2026/0014

**Proposed steel containers to be converted into a private bar with car sales offices above.
(Retrospective)**

6 PROPOSED FRONT ELEVATION
1 : 50

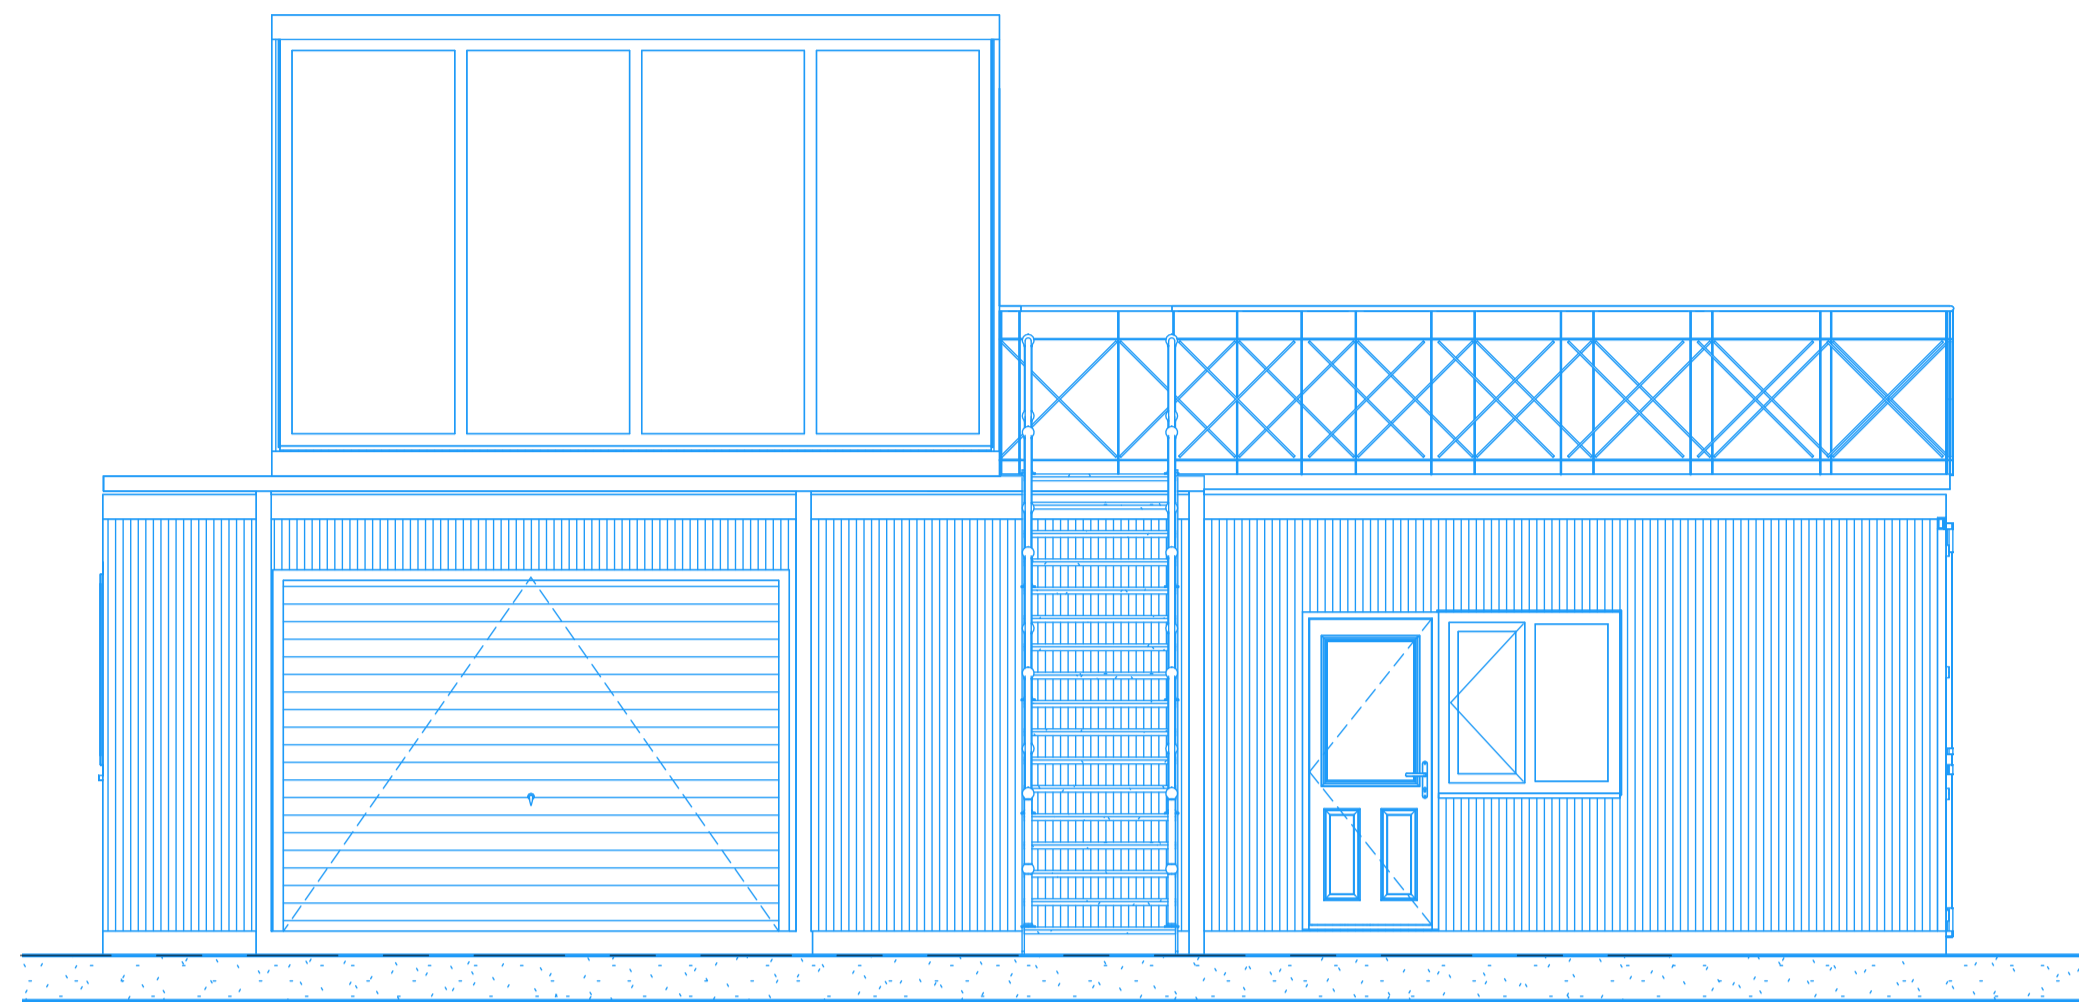
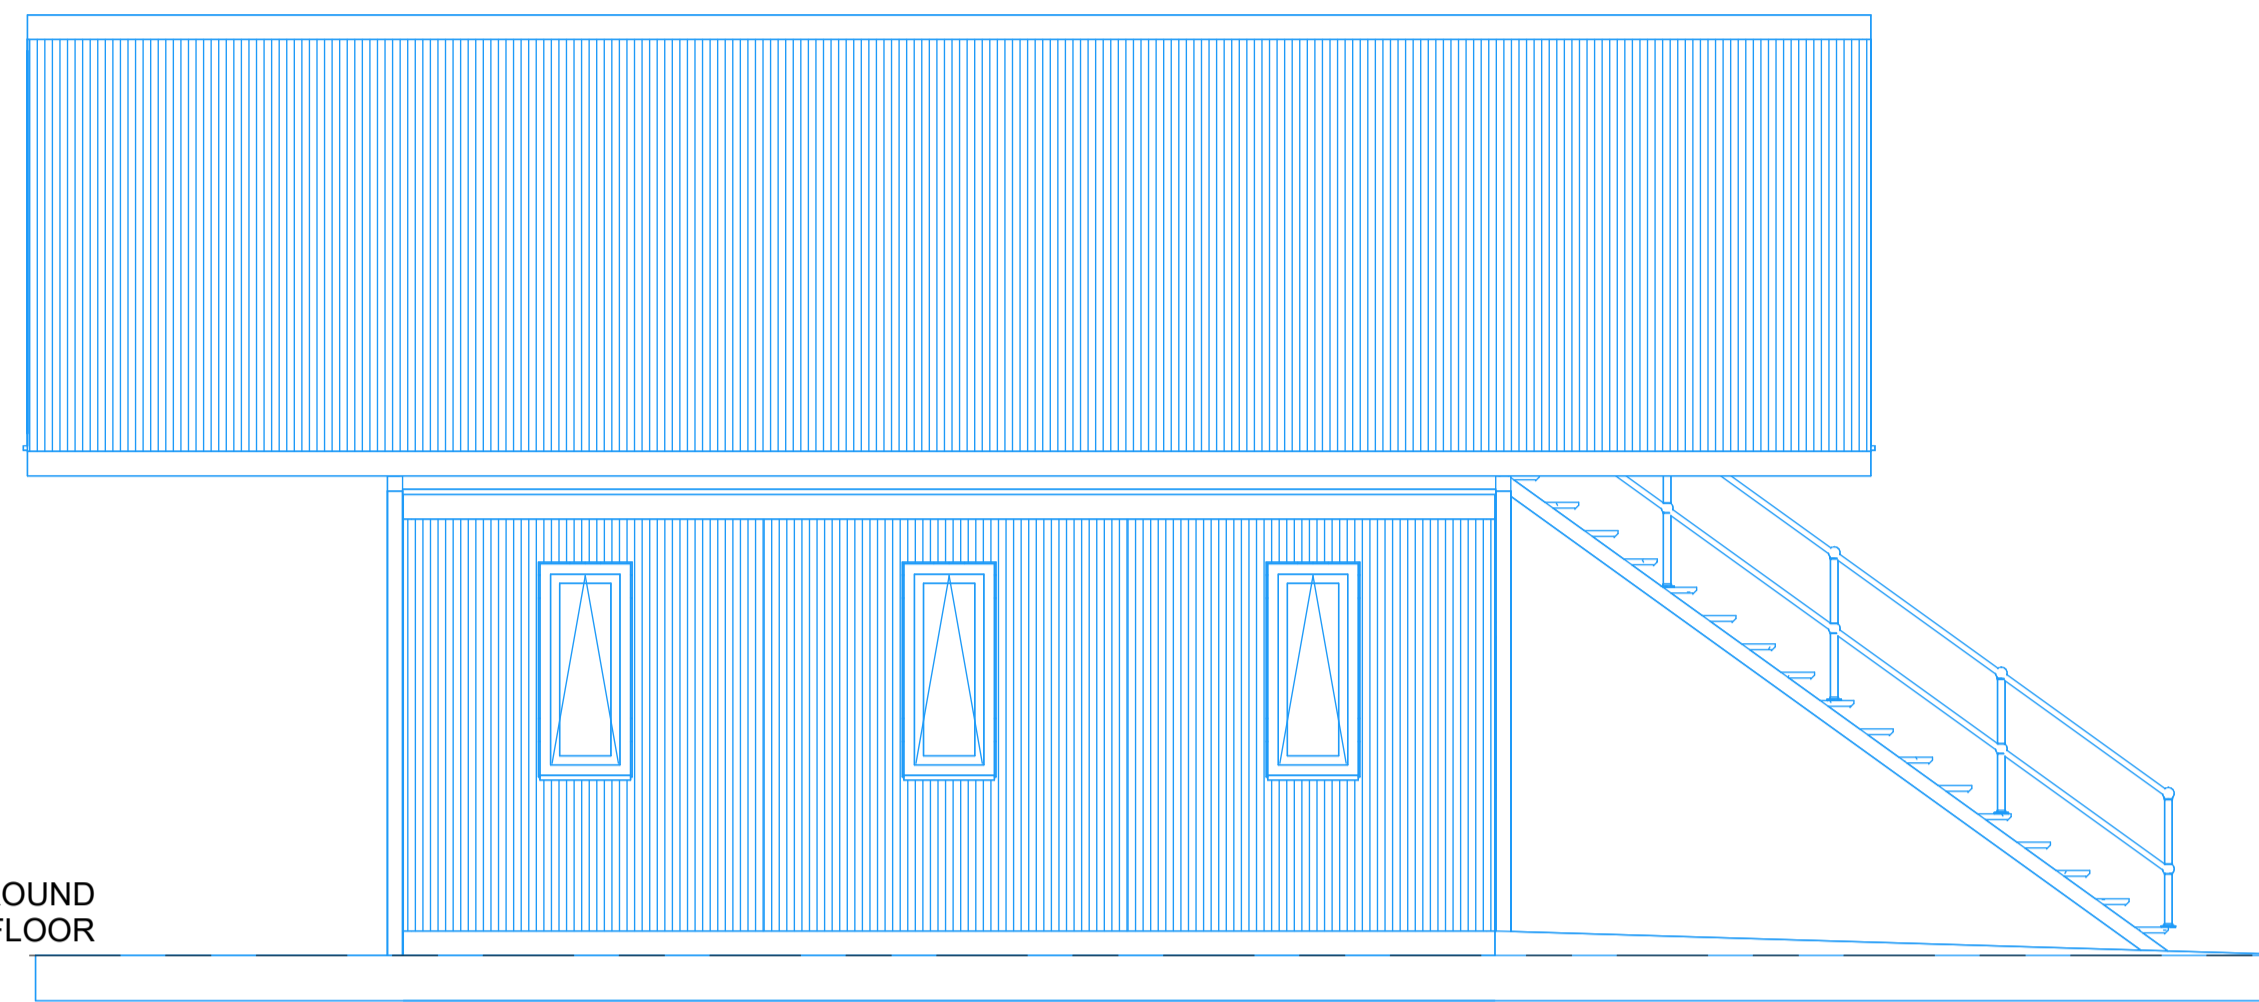
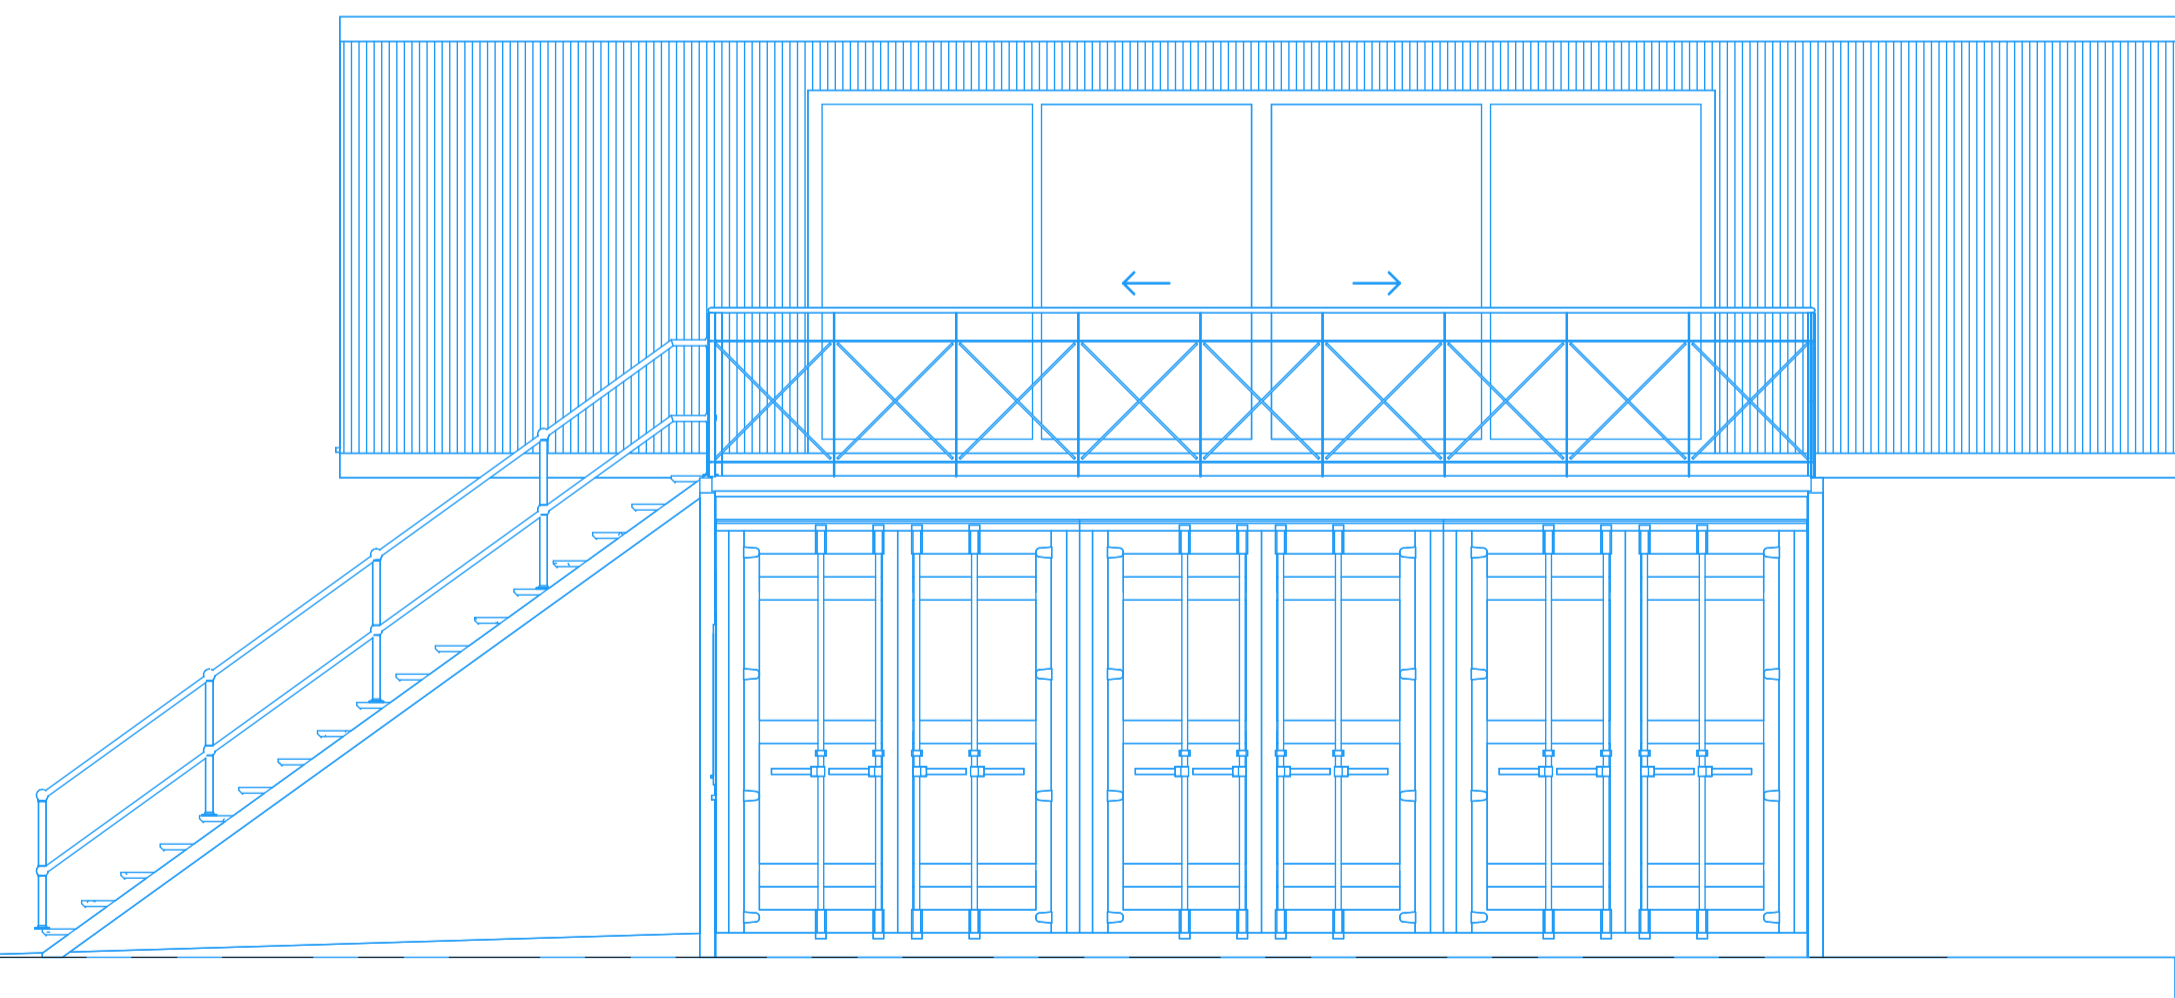
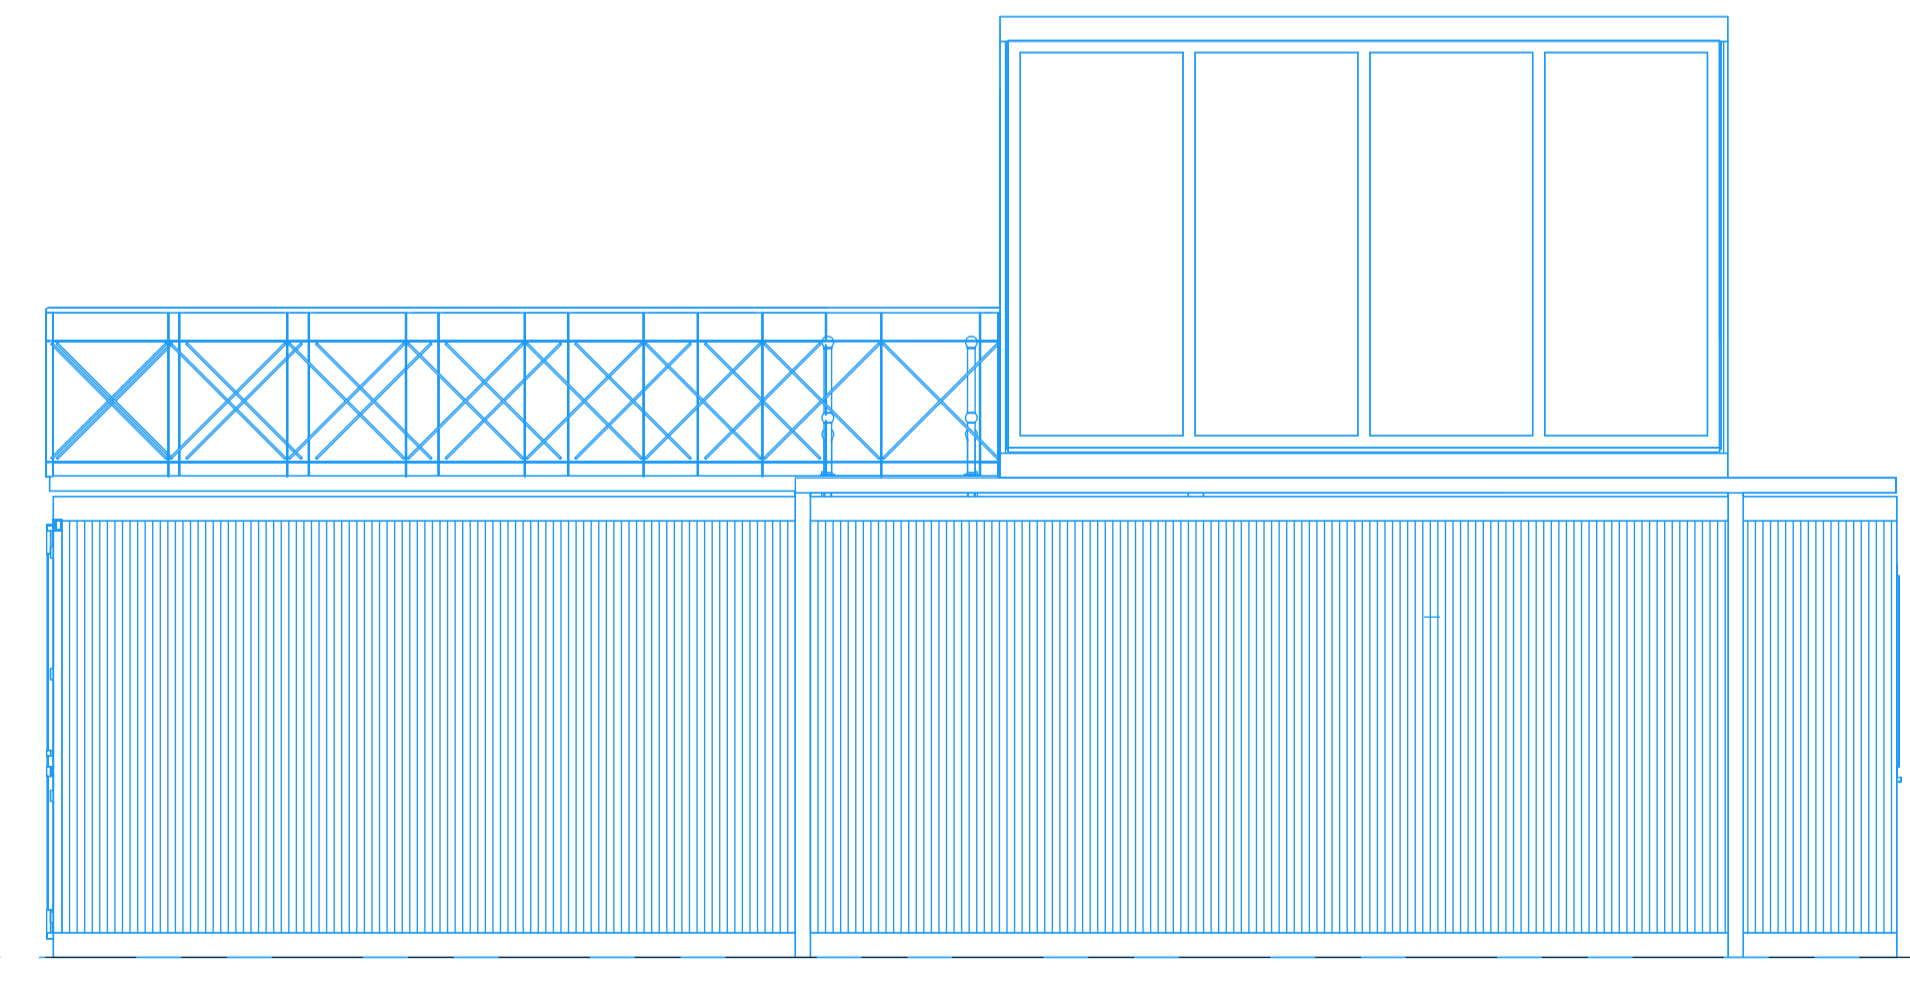
The proposed development comprises the siting of two steel shipping containers to be used as a car sales office and private bar. By virtue of their design, appearance, and temporary form, the containers would appear as incongruous and visually intrusive features within the locality. Whilst the site is located adjacent to an industrial estate, the surrounding development predominantly comprises purpose-built warehouses and commercial buildings of a permanent and coherent design. The containers would not reflect the established character, appearance, scale or built form of these buildings and would therefore appear out of keeping with the prevailing character of the area.
